Our ref: WA/2023/130558/02-L01
Your ref: 23/00977/OUT
Date: 29 November 2023

Outline planning application (except for access) for residential development of up to 60 dwellings (use class C3) including a community facility, new vehicular and pedestrian access off Claydon Road, public open space and associated landscaping, earthworks, parking, engineering works and infrastructure

OS Parcel 9195 north of, Claydon Road, Cropredy

Thank you for re-consulting us on the above application following the submission of additional details. We have reviewed the submitted Flood Risk Assessment reference 016_8210439_SM_Flood_Risk_Assessment, Issue 5, dated 16 August 2023.

Topographical Survey & Flood Zones Overlay

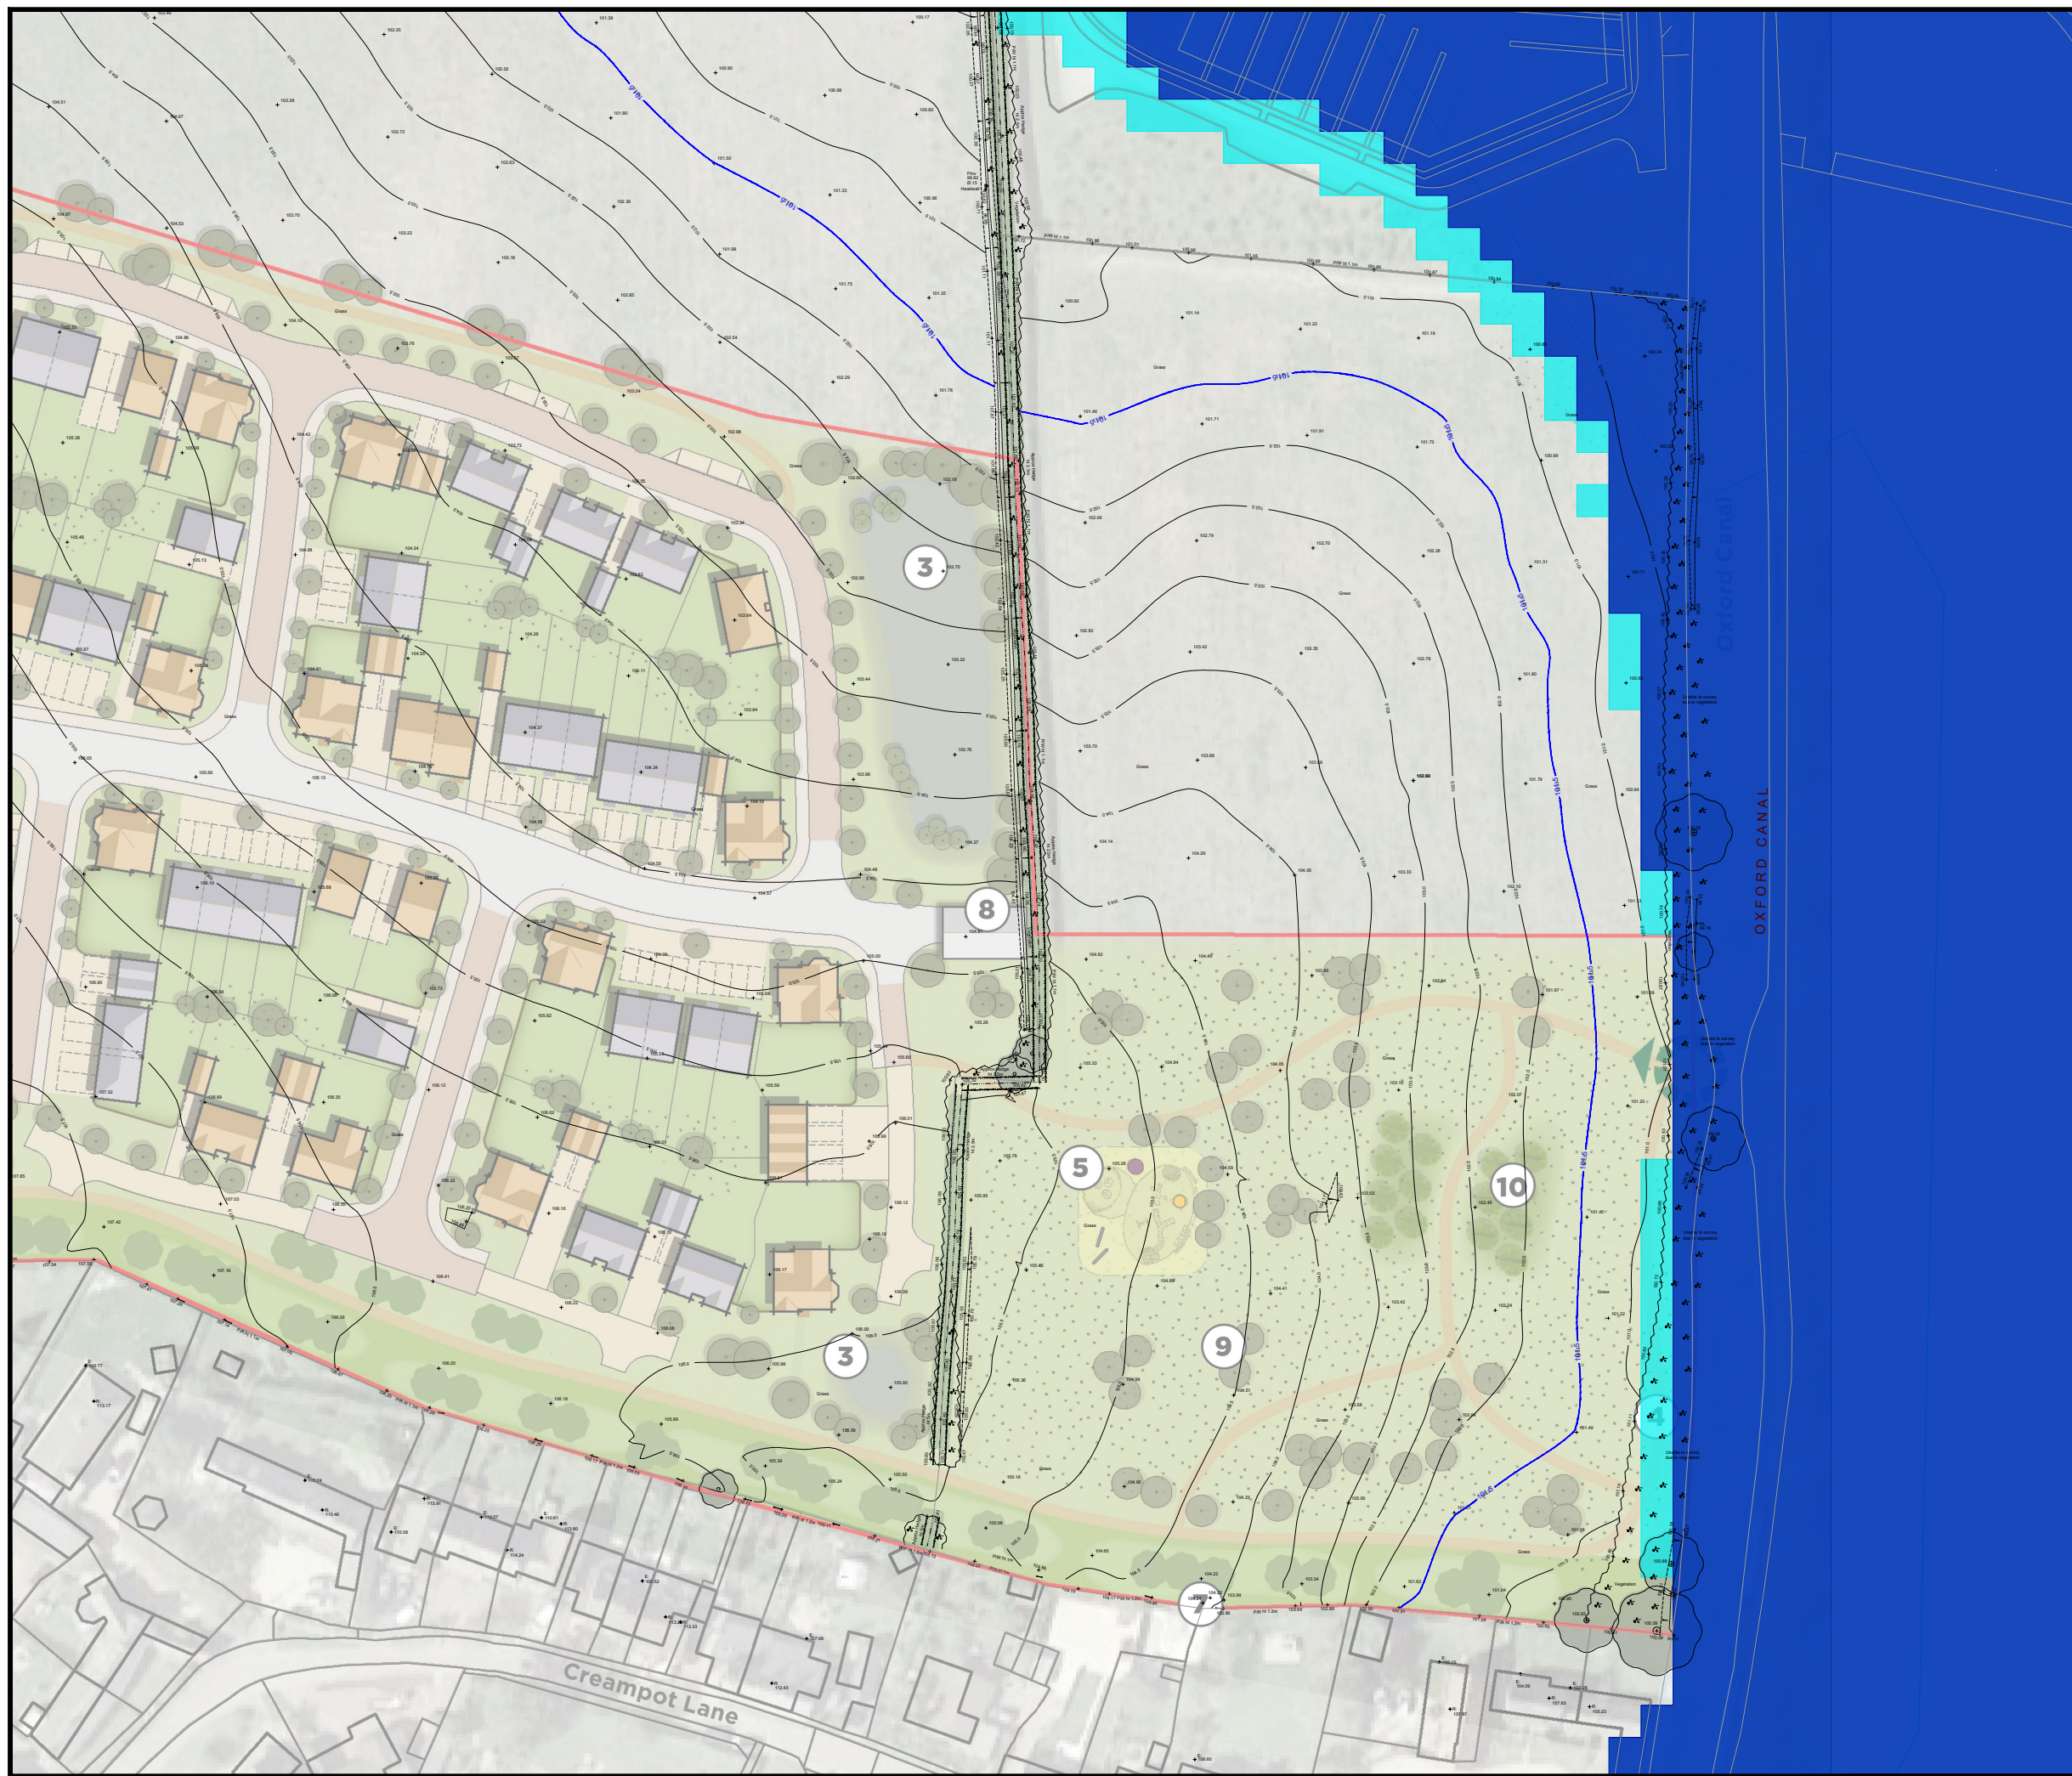
Using this level, the applicant has plotted the expected extent of flooding against topographical site levels and this shows that a small area of land alongside the canal would be at risk of flooding both now and in the future due to climate change. Providing this area is retained as open space and there is no raising of land levels or positioning

of any structures that would divert flow within this zone, we are satisfied that the development as proposed would not increase the risk of flooding.

No development approved by this planning permission shall commence until such a time as a scheme to protect land at risk of flooding as shown in the approved Flood Risk Assessment reference 016_8210439_SM_Flood_Risk_Assessment, Issue 5, dated 16 August 2023, has been submitted to and approved in writing by the local planning authority. The scheme shall include:

- Details of hard and soft landscaping schemes
- Details of existing and proposed ground levels

The scheme shall demonstrate that flood risk will not increase and shall be fully implemented and subsequently maintained as approved for the lifetime of the development.
